Subject: TEN24/00060/FUL HA Recommendation

Application No.	24/00060/FUL
Proposal.	Conversion of existing property to two flats
Address.	19 Cliff Road Dovercourt Harwich Essex CO12 3PP

BLOCK PLAN SCALE 1:500

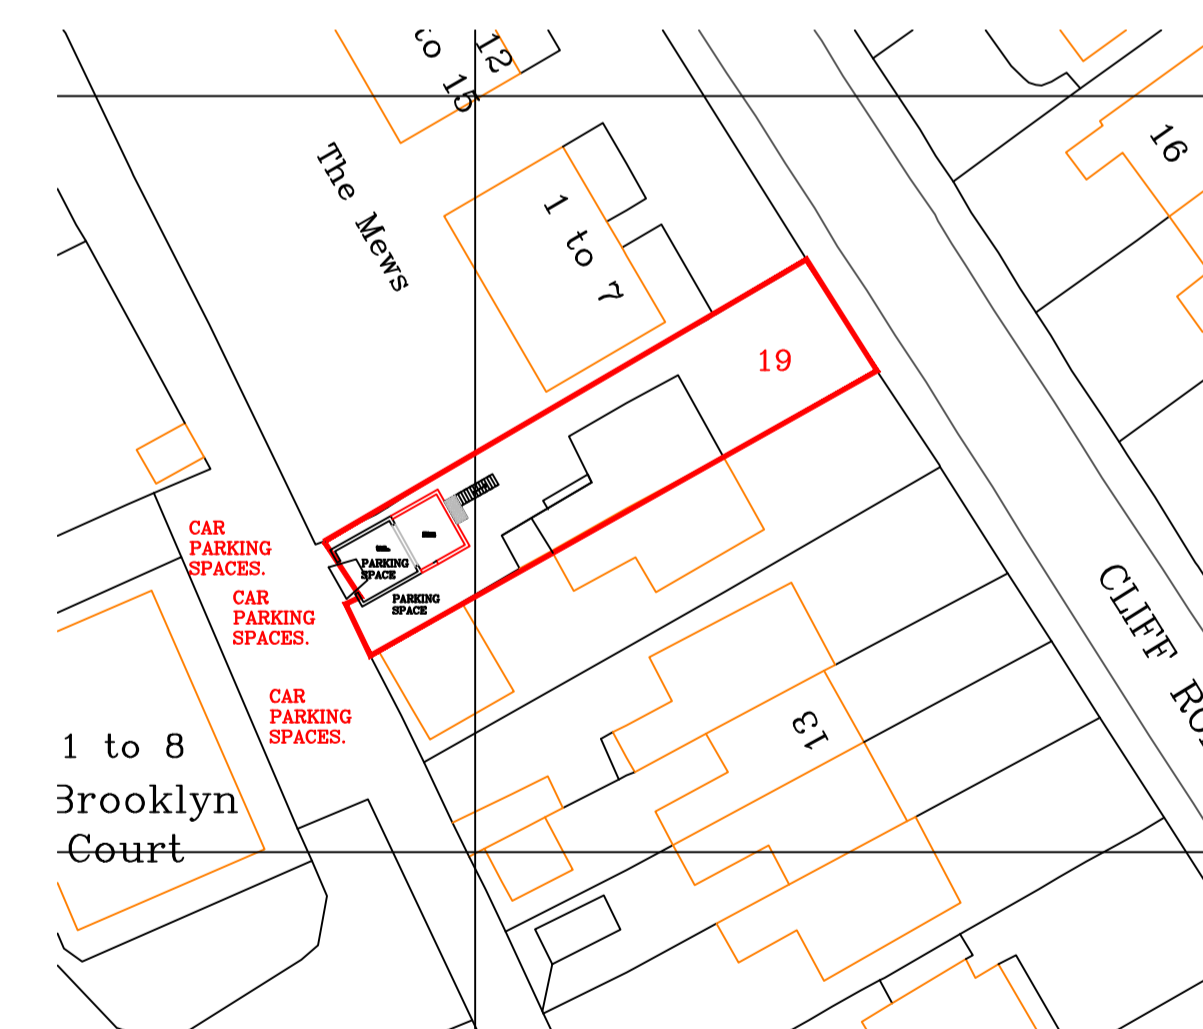
1. The vehicular access shall be constructed at right angles to the highway boundary and to the existing carriageway. The width of the access at its junction with the highway shall not be less than 3 metres, shall be retained at that width for 6 metres within the site and shall be provided with an appropriate dropped kerb vehicular crossing of the footway.

2. No unbound material shall be used in the surface treatment of the vehicular access within 6 metres of the highway boundary.
